Recommendation Report for Planning Permission

REF NO: AW/240/20/PL

LOCATION: 17 Nyewood Lane
Aldwick
PO21 2QB

PROPOSAL: Change of use of former residential parenting unit (C2 Residential Institution) to 8 bed House in Multiple Occupation (C4 Sui Generis). This site is in CIL Zone 4 (Zero Rated) as other development.

Plan Produced for: CHANGE OF USE APPLICATION

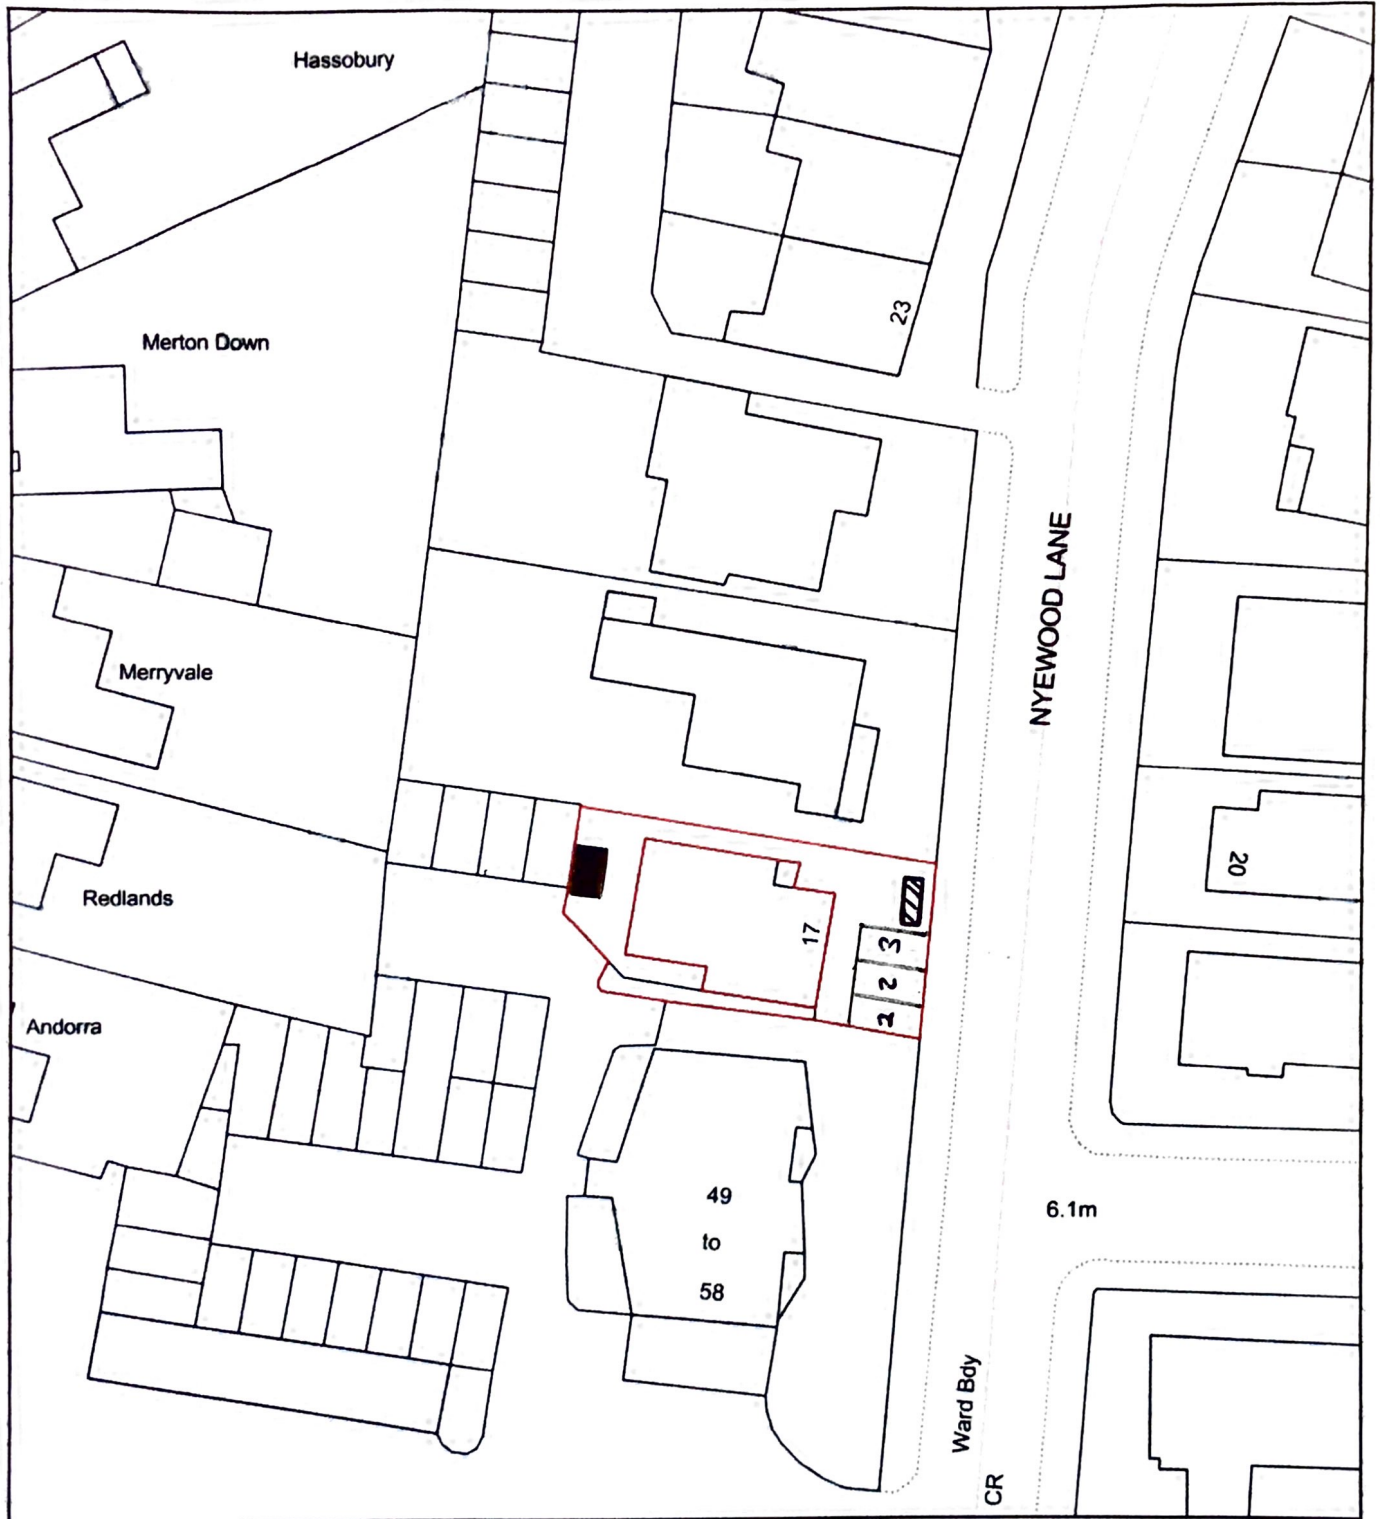
The 3 parking spaces as shown satisfy the requirement of the Arun Parking Standards, however WSCC state that inspection of the plan shows the hardstanding (6.7m x 7m) is only large enough to accommodate 2 parking spaces. WSCC local mapping shows there are comprehensive parking restrictions prohibiting vehicles from parking in places that would be detriment to highway safety. WSCC do not consider that reduction of 1 parking space detrimentally affects highway safety.

17 NYEWOOD
GROUND FLOOR
1:50 SCALE

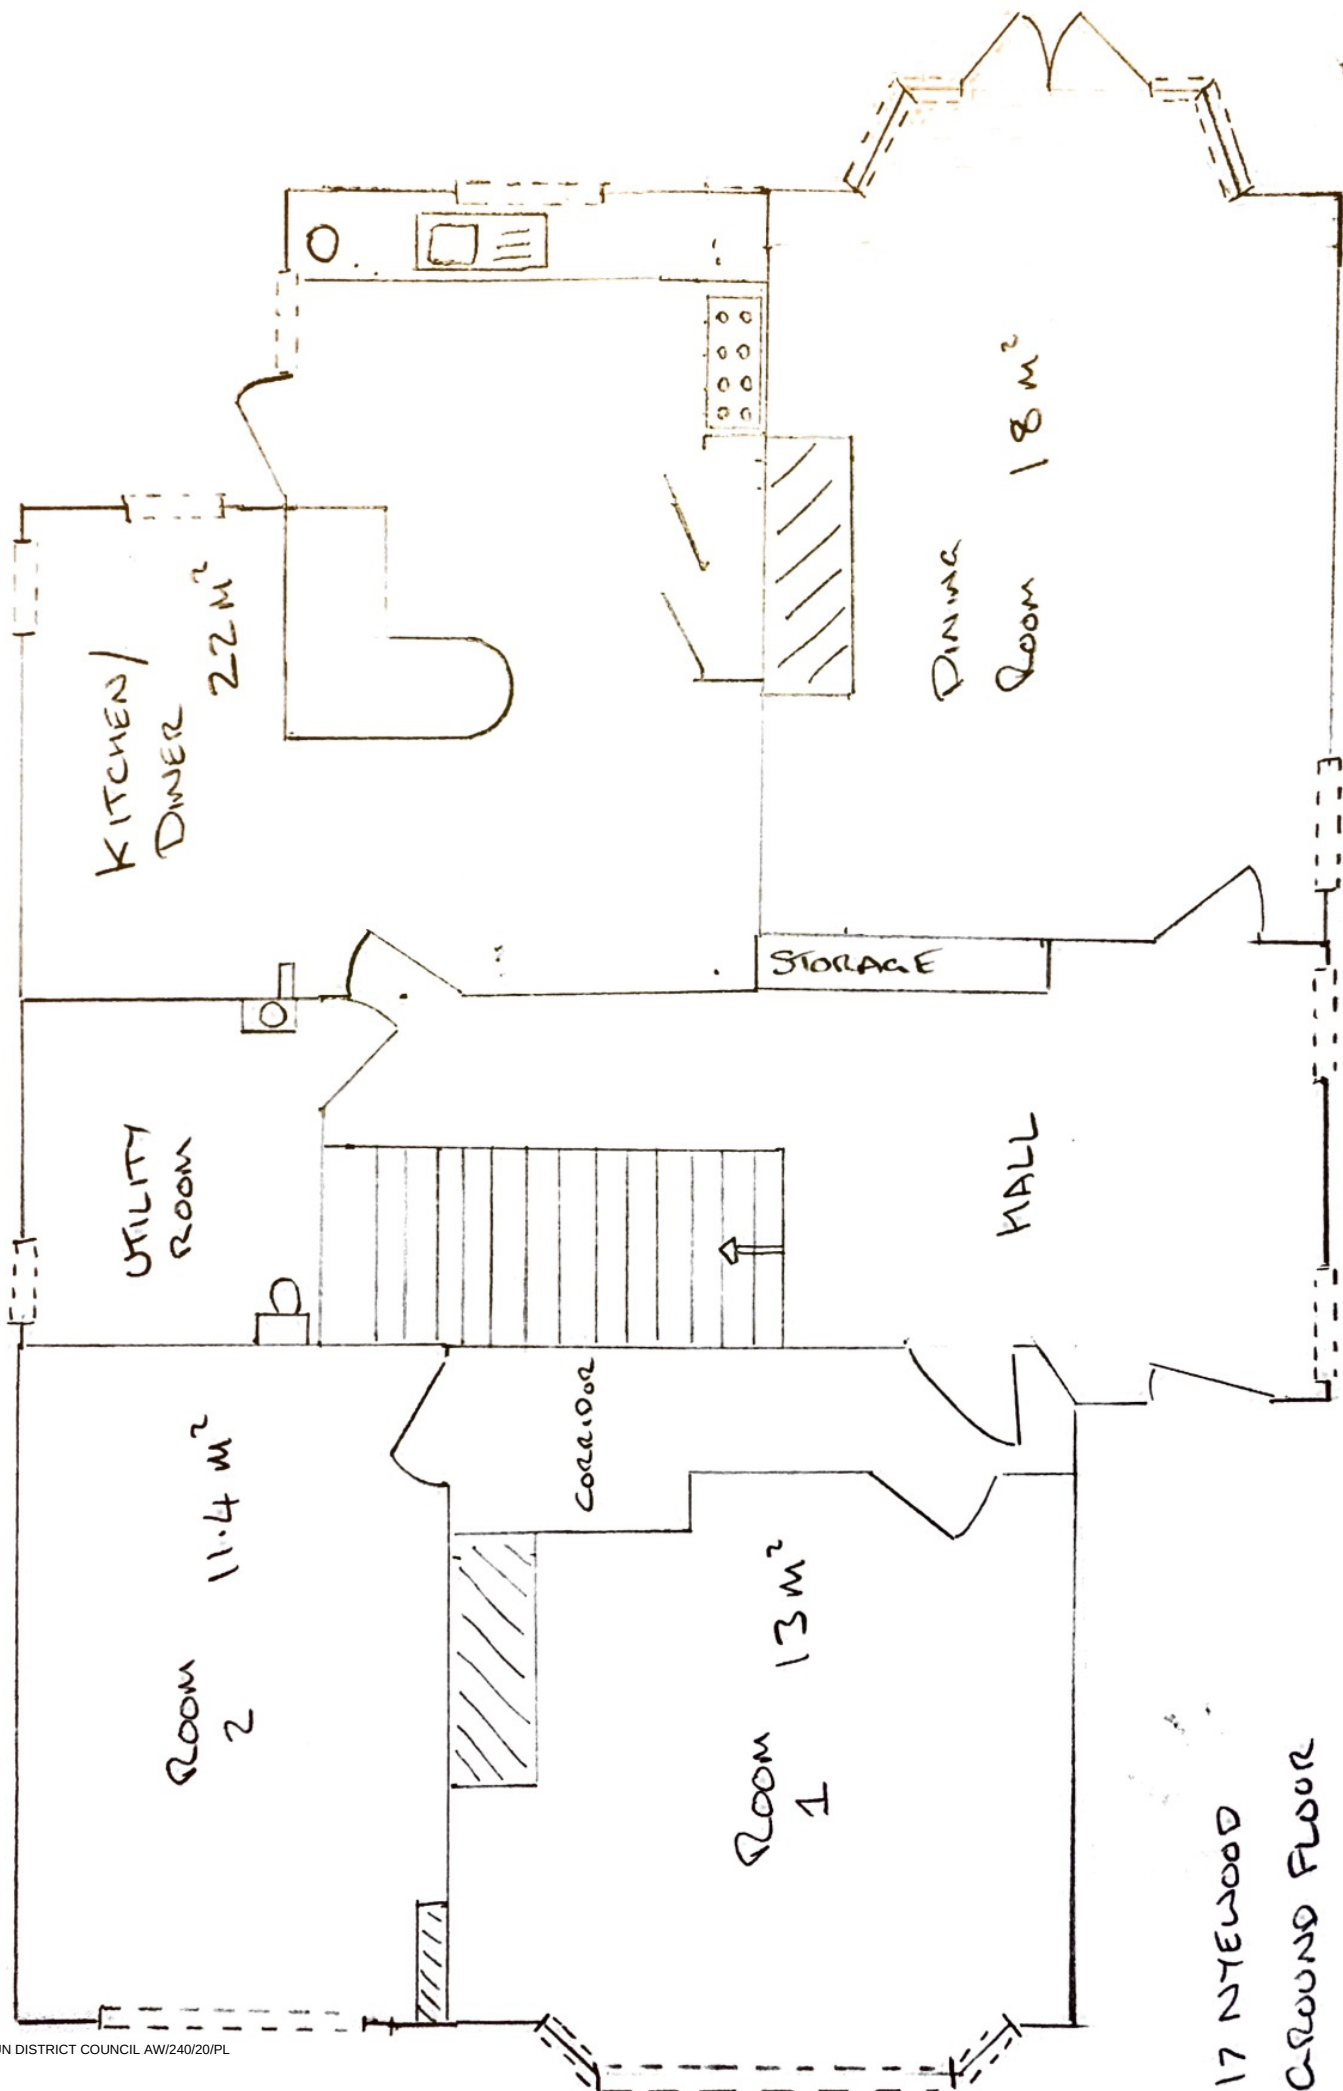
- Rudimentary plans make it impossible accurately to gauge dimensions of rooms rather than the overall area.
- Insufficient provision of bathrooms/shower room.

- Insufficient information was given regarding the precise sizes of rooms and the safety facilities.
- Regret missed opportunity to provide visitor accommodation/high quality single dwelling.

- The provided information/drawings are sufficient for assessing the development.
- The applicant confirmed the HMO is for 8 persons accommodated in 8 rooms.
- Provision of an electric charging point will be a subject to the condition.
- WSCC, the LHA raises no concerns over the Vehicle Parking.

- The drawings are to scale and of a reasonable quality.
- The previous use was for a Residential Family Assessment Centre, accommodating 6 families as such the proposed would not be an intensification of use.
- WSCC commented: ' In principle, the existing C2 use could generate vehicular trips of a similar quantity to that of the proposed 8 bed dwelling. The Local Highways Authority (LHA) therefore accepts that the proposed will not result in a material intensification of use of the existing access track or access point onto the maintained highway network at Nyewood Lane.'
- Fire Safety is addressed in Comments from Private Sector Housing.
- Other issues are addressed below.

In the case of this application, all of the rooms comply with the smallest bedroom, 7.7m² and the largest 20.3m².
